# KITTITAS COUNTY DEPARTMENT OF PUBLIC WORKS

January 26, 2021

Below is a list of questions and comments relating to the grading permit associated with the Hansen Road Development.

DRAWING NO.	C1.0
PROJECT NO.	20.010
DATE:	11/23/20
SHEET NO.	1 OF 10

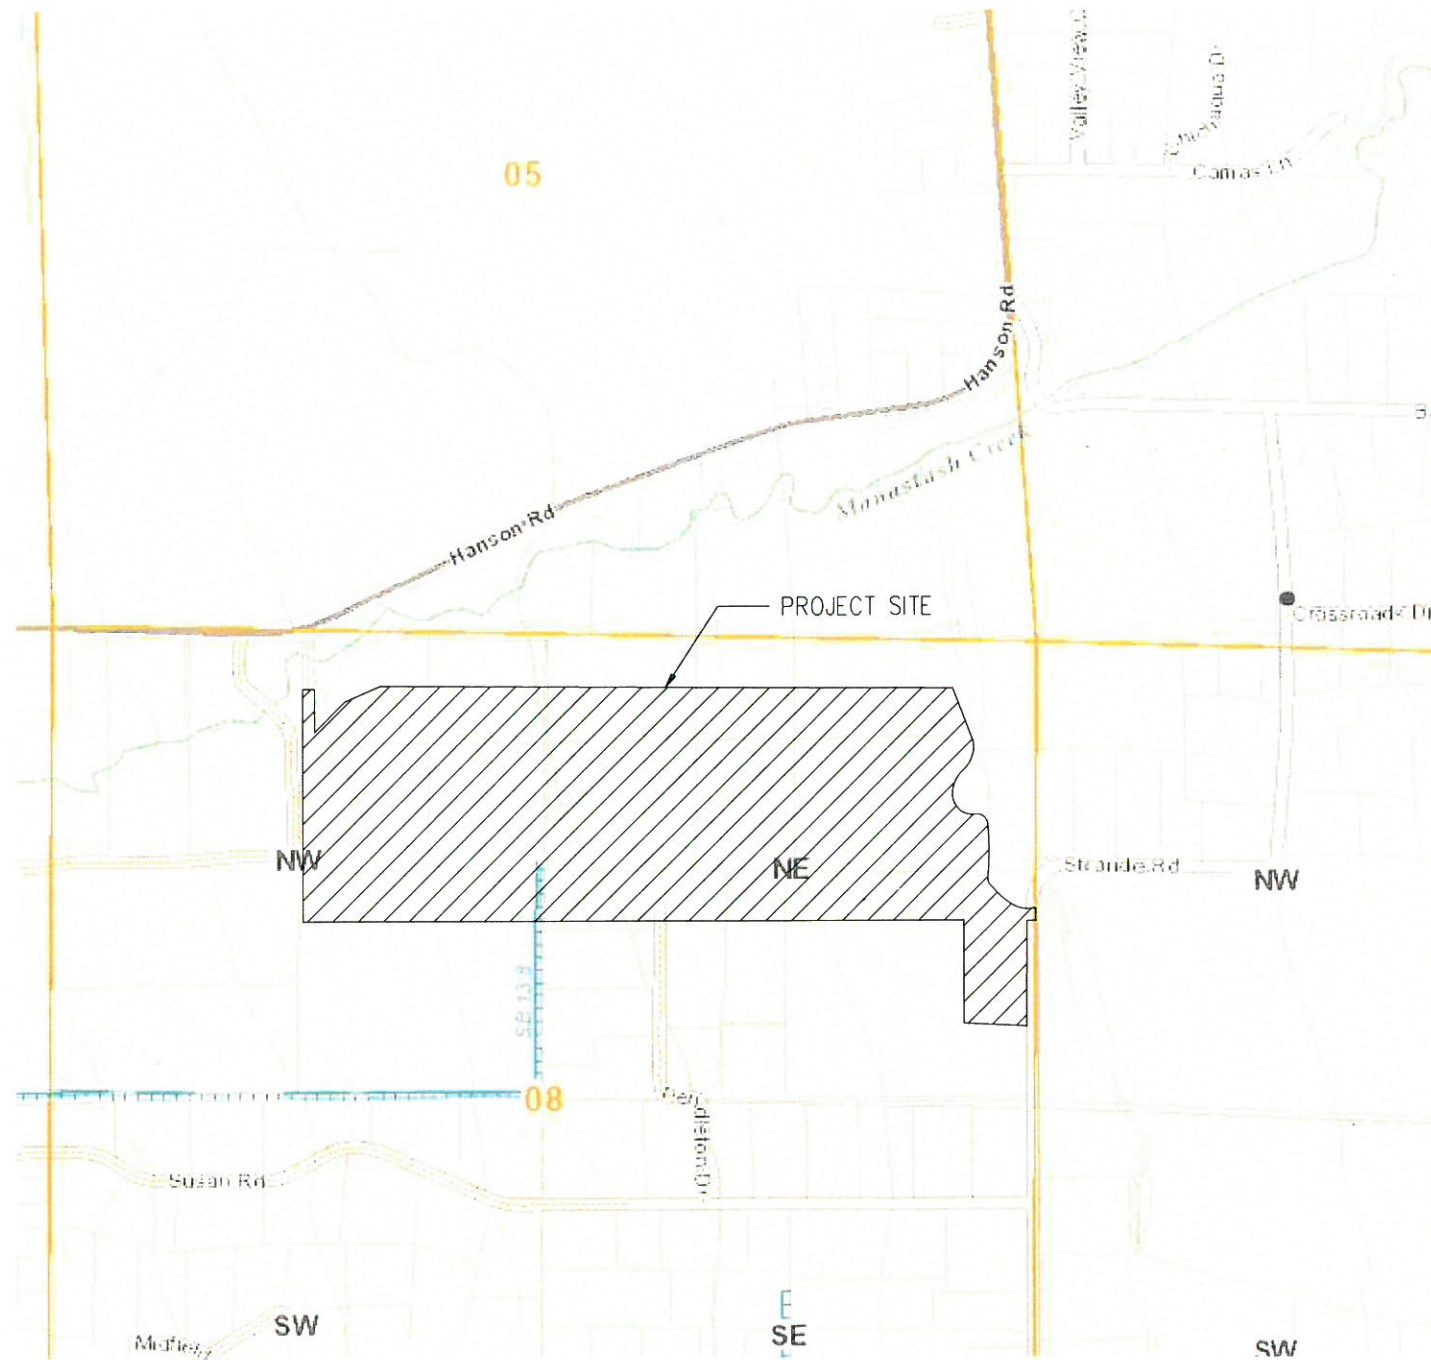
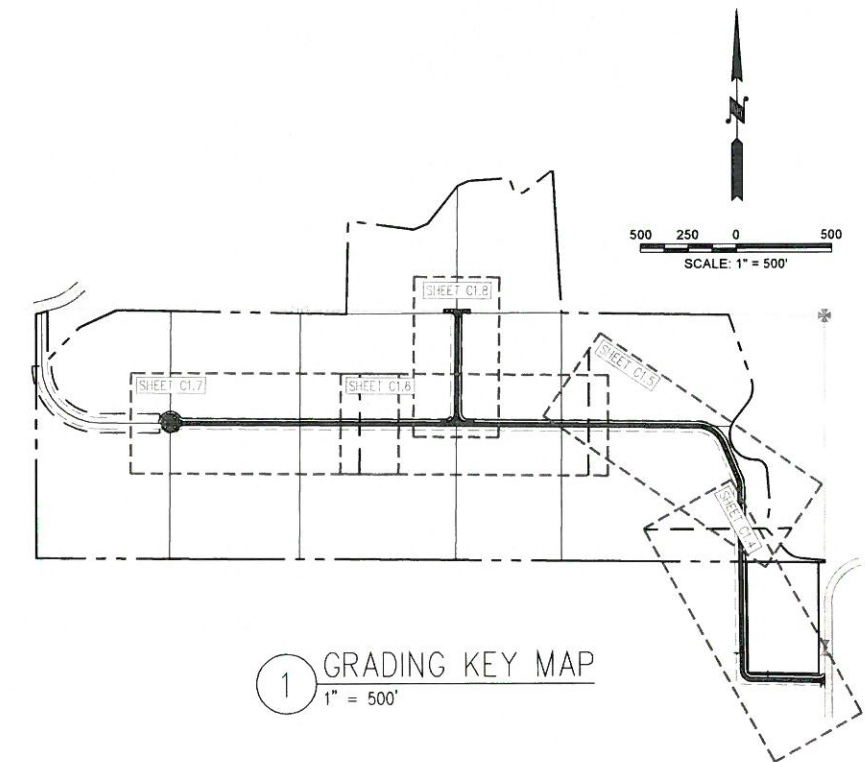
1. Sheet C1.0, the Project Site identified does not appear to line up with the map area.
2. Sheet C1.1 shows parcel 836636 as "Lot 13", this parcel appears to be under a separate ownership. Is this parcel correctly identified as part of this project? The road appears to be placed on parcel 748433, which is not labeled as being included in the project.

DRAWING NO.	C1.1
PROJECT NO.	20.010
DATE:	11/23/20
SHEET NO.	2 OF 10

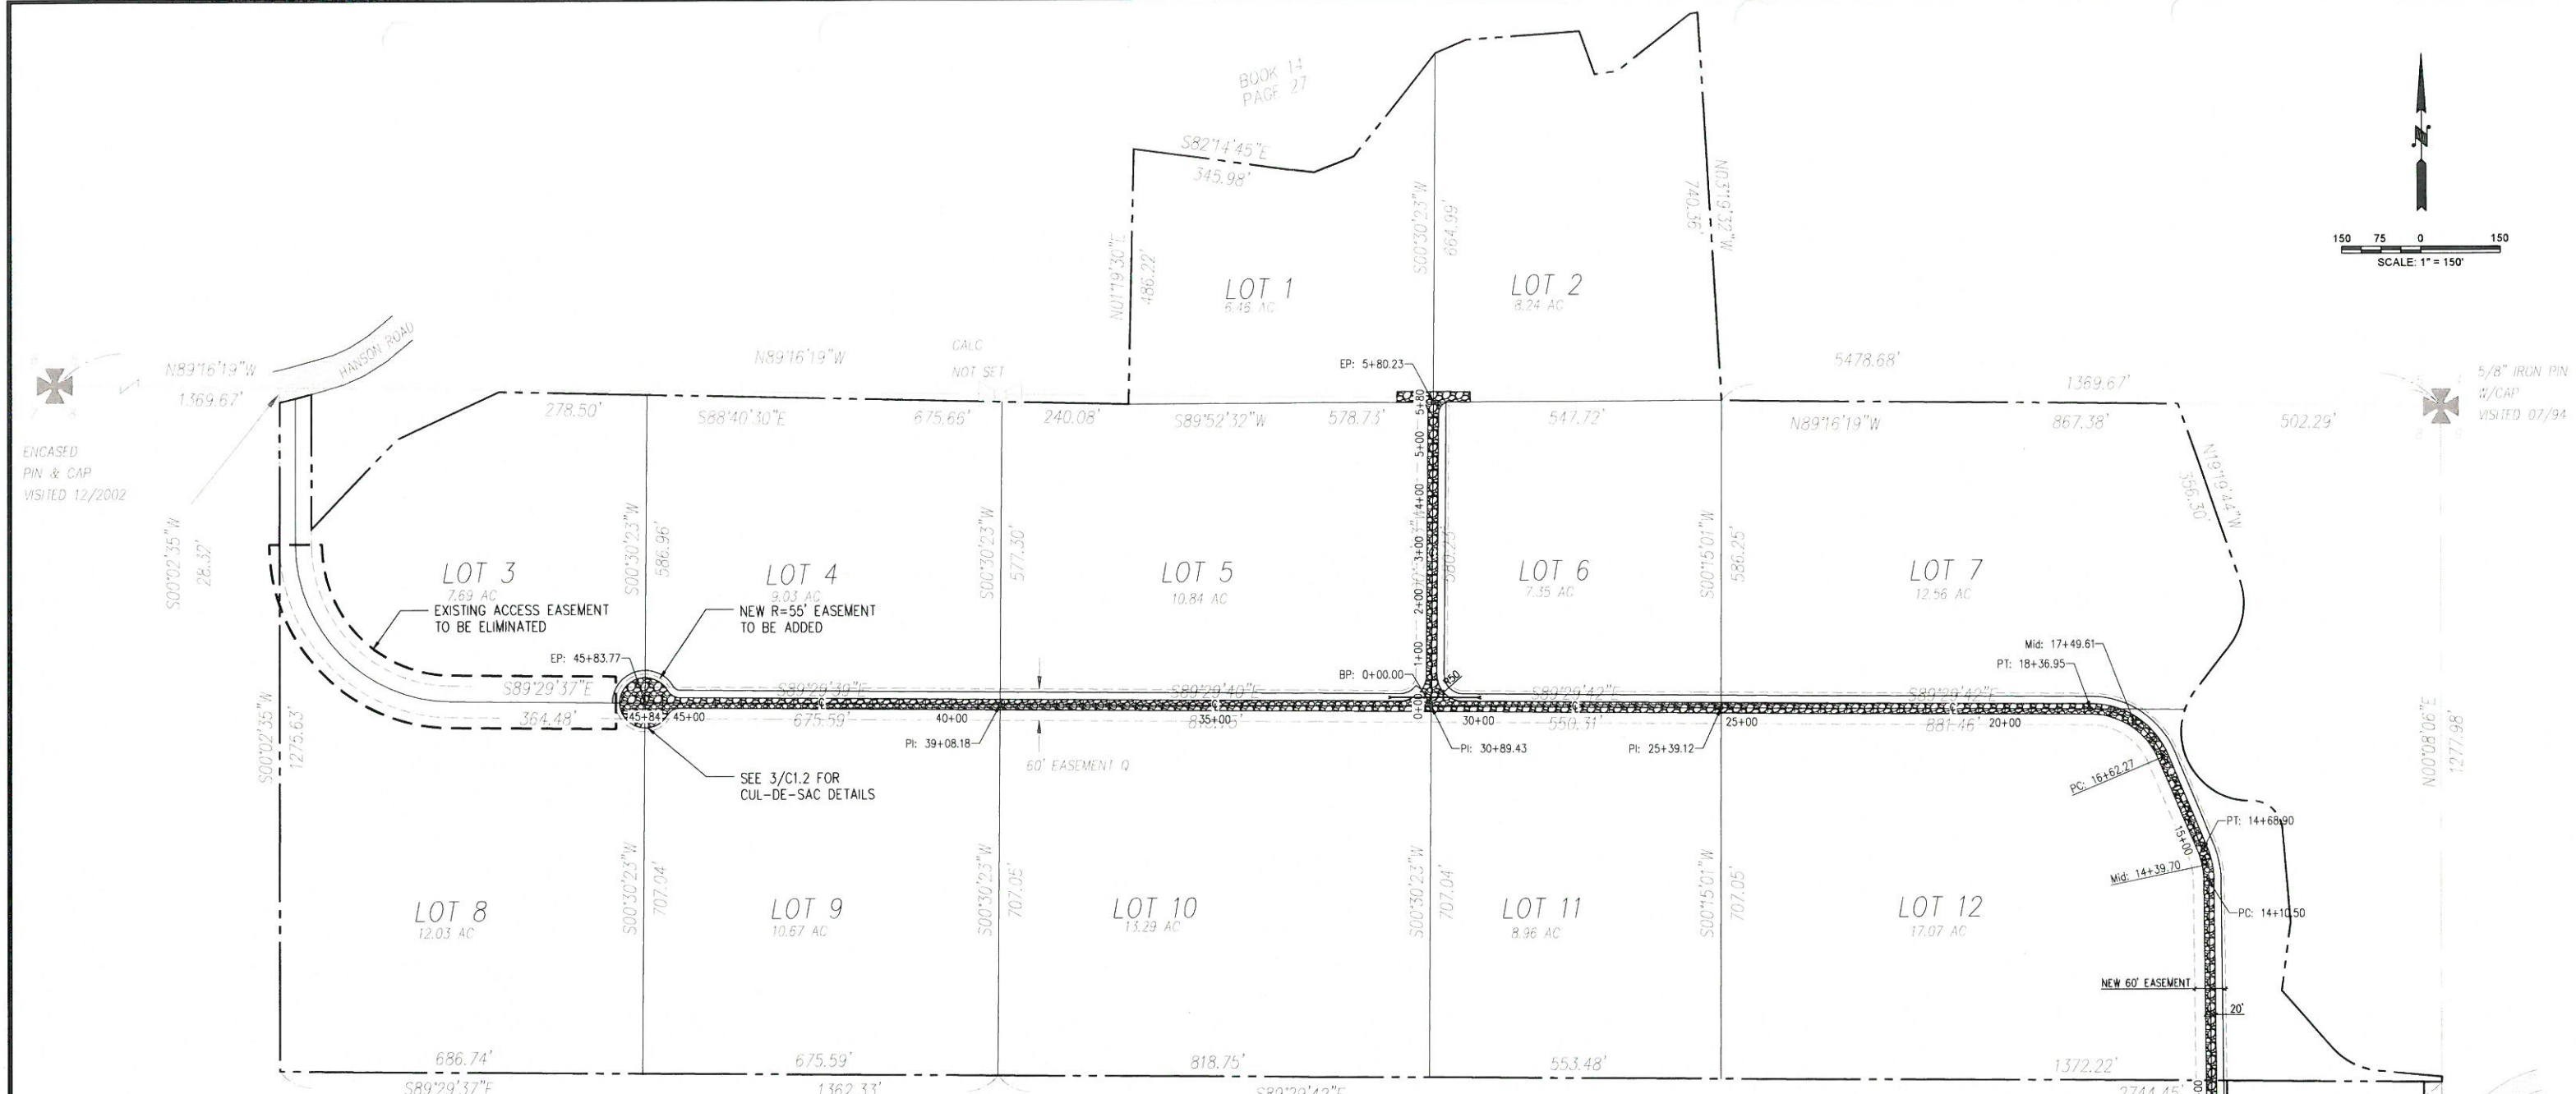
3. Original administrative segregation included 12 lots. Parcel 748433 should be shown as having access to proposed private roadway.
4. Throughout the plan set, notes refer the reader to details on page C1.2. For example, sheet C1.1 has notes for the cul-de-sac, paved apron, gravel road, and drainage basin referring the reader to 'see 2/C1.2', 'see 3/C1.2', etc. Similar notes appear on sheet C1.9. Should these notes refer the reader to C1.9?

5. Notes on sheets C1.1 and C1.7 mention that there is an existing access easement off Hansen Road to be eliminated. Does this mean that there is an existing road that needs to be removed? If so, please provide additional details on the removal of the road and adjust the TESC plan to include the road removal within its limits.

10. Sheet C1.1 approximate station 3+00 Rt, calls for W1-2, please consider the use of W1-1.
11. C1.8: The hammerhead turnaround shown on C1.8 needs to have 28' radii in the intersection to meet the international fire code.

DRAWING NO.	C1.4
PROJECT NO.	20.010
DATE:	11/23/20
SHEET NO.	5 OF 10

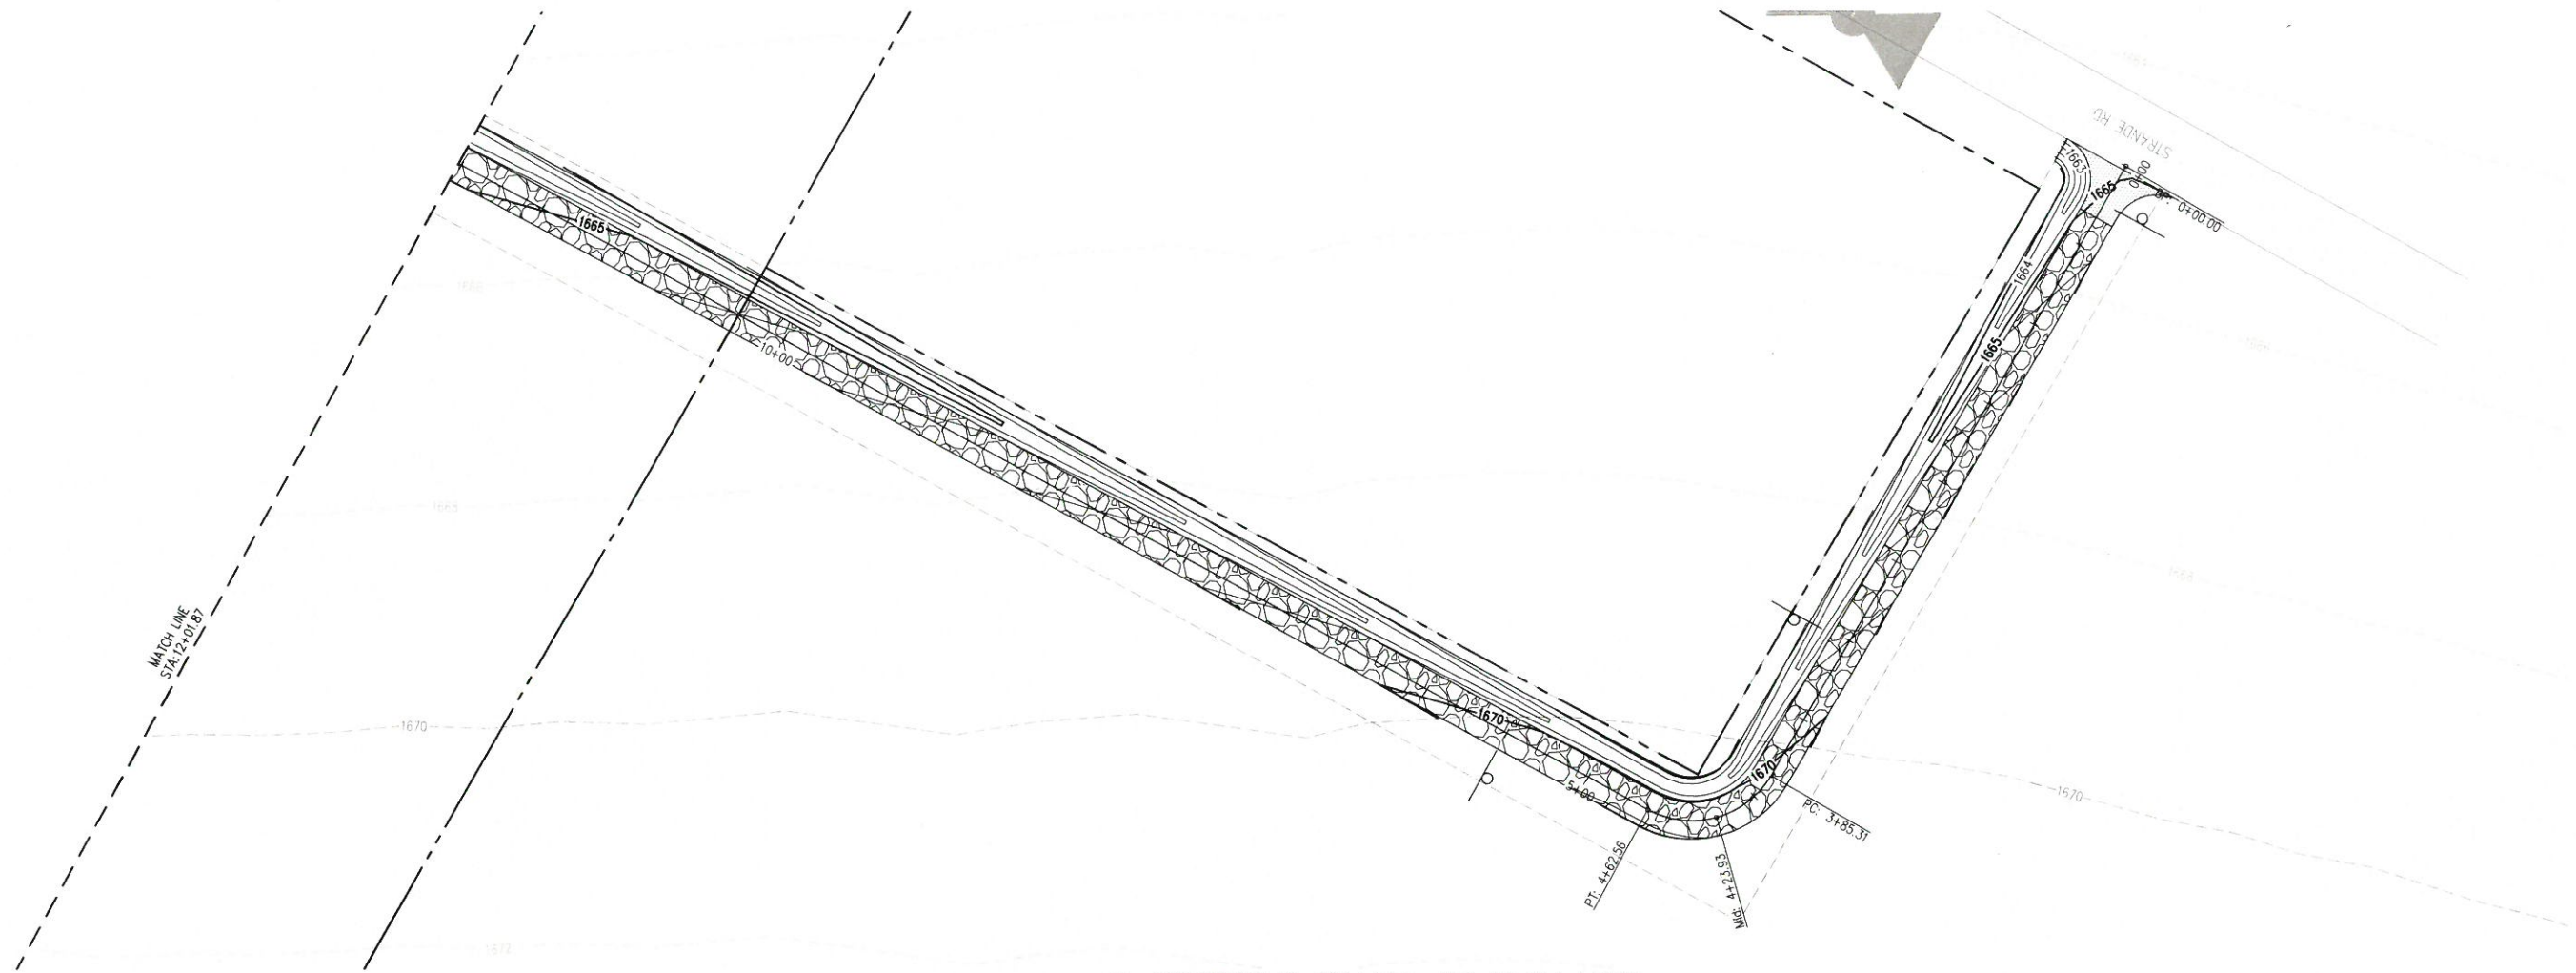
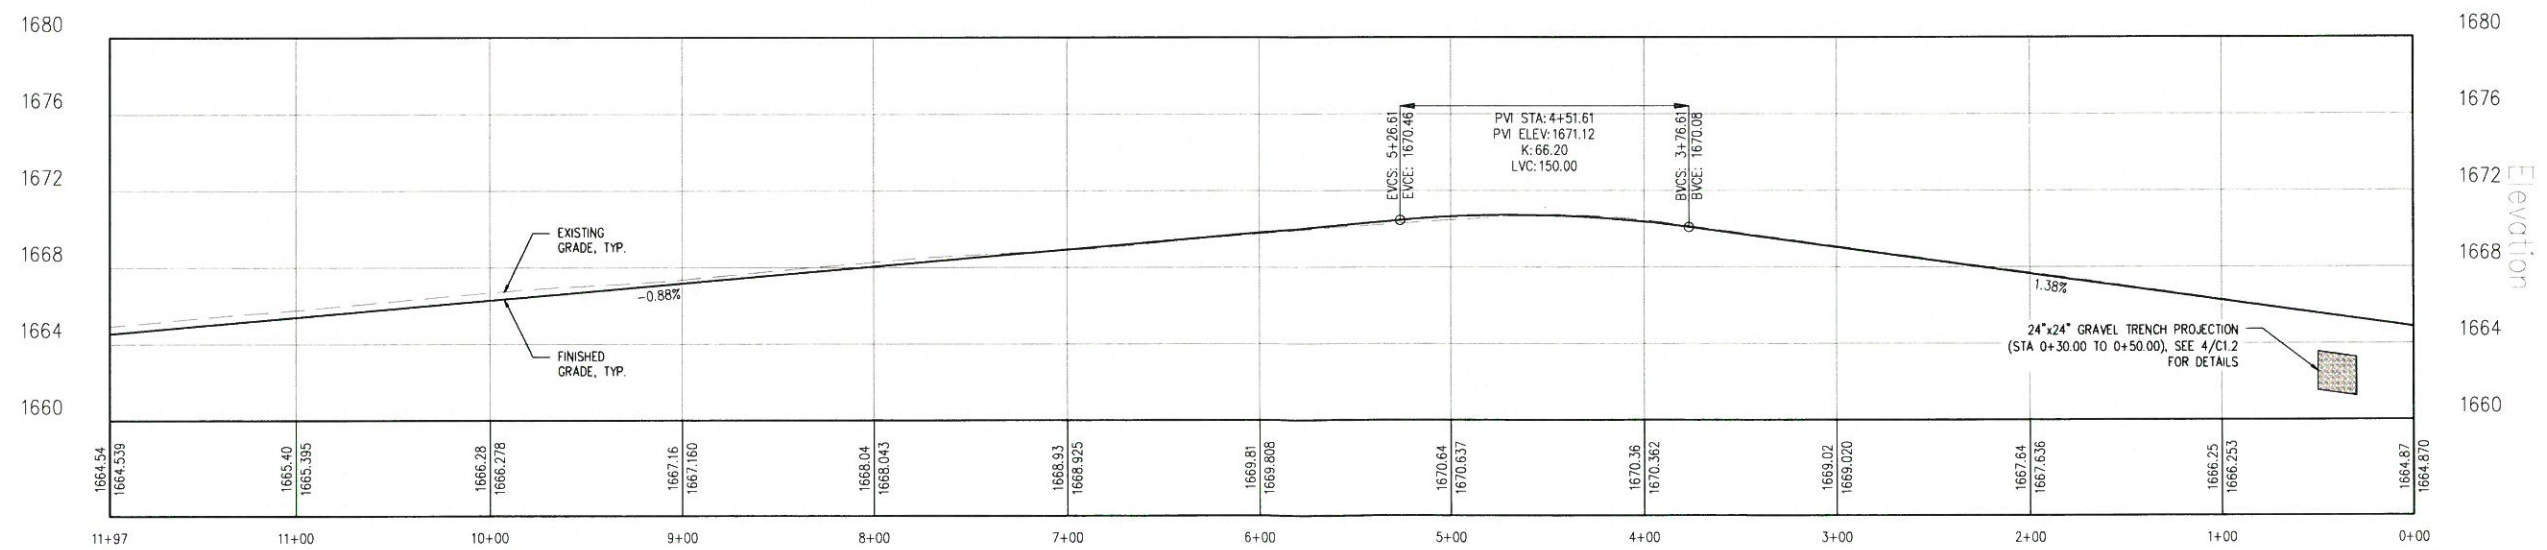
19. C1.4 through C1.8 please identify lot lines and lots.
  20. Identify the existing access to parcel 836636 and identify the spacing from edge of access to the edge of the proposed access. Ensure spacing meets requirements of KCC 12.5, particularly Table 5-1.
